KITTITAS COUNTY COMMUNITY DEVELOPMENT SERVICES

March 5, 2019

Subject: Evergreen Ridge PUD, Rockberry Loop (LPF-19-00001) Final Long Plat – Staff Review and Request for Additional Information

DWN BY D.L.P./G.W.	DATE 02/2019	JOB NO. 16078
CHKD BY D.L.P.	SCALE 1" = 200'	SHEET 1 OF 6

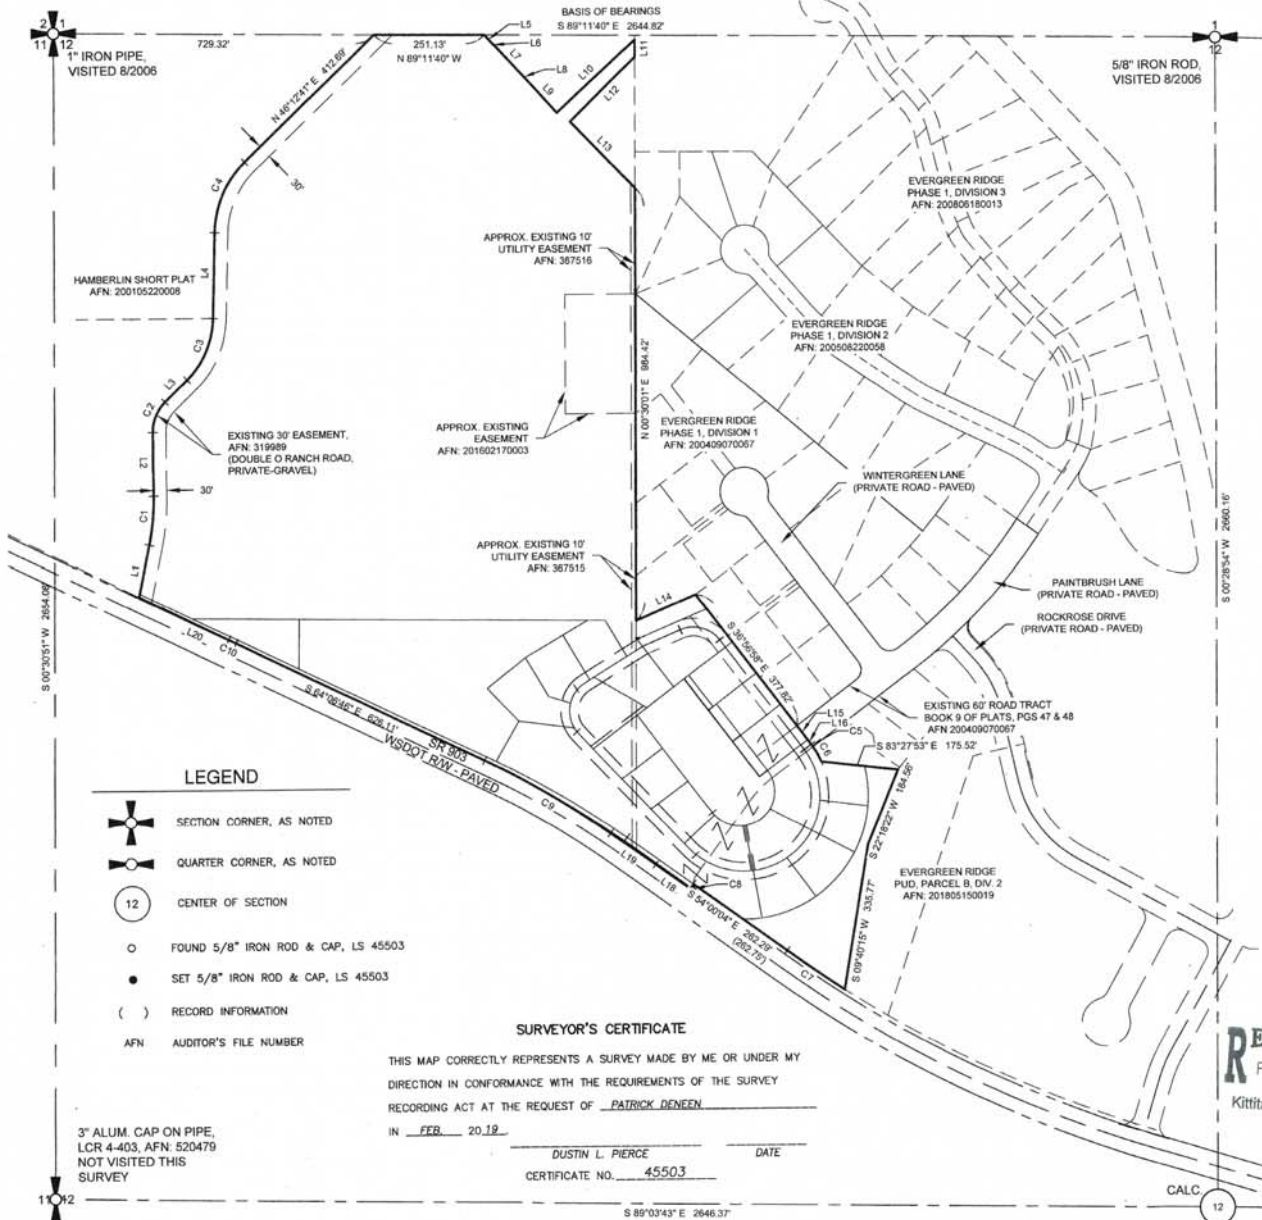
- Required changes/ information
 1. Provide density information showing this plat does not exceed approved density for Tract A of the approved Evergreen Ridge PUD.
 2. Identify future intent for tracts A, B, and C shown on face of plat.
 3. Include additional parcel numbers on application (shown as lots 1 and 3 on mylar).
 4. Additional signatures of other land owners on application.
 5. Additional dedications for all land owners on sheet 6 of mylar.
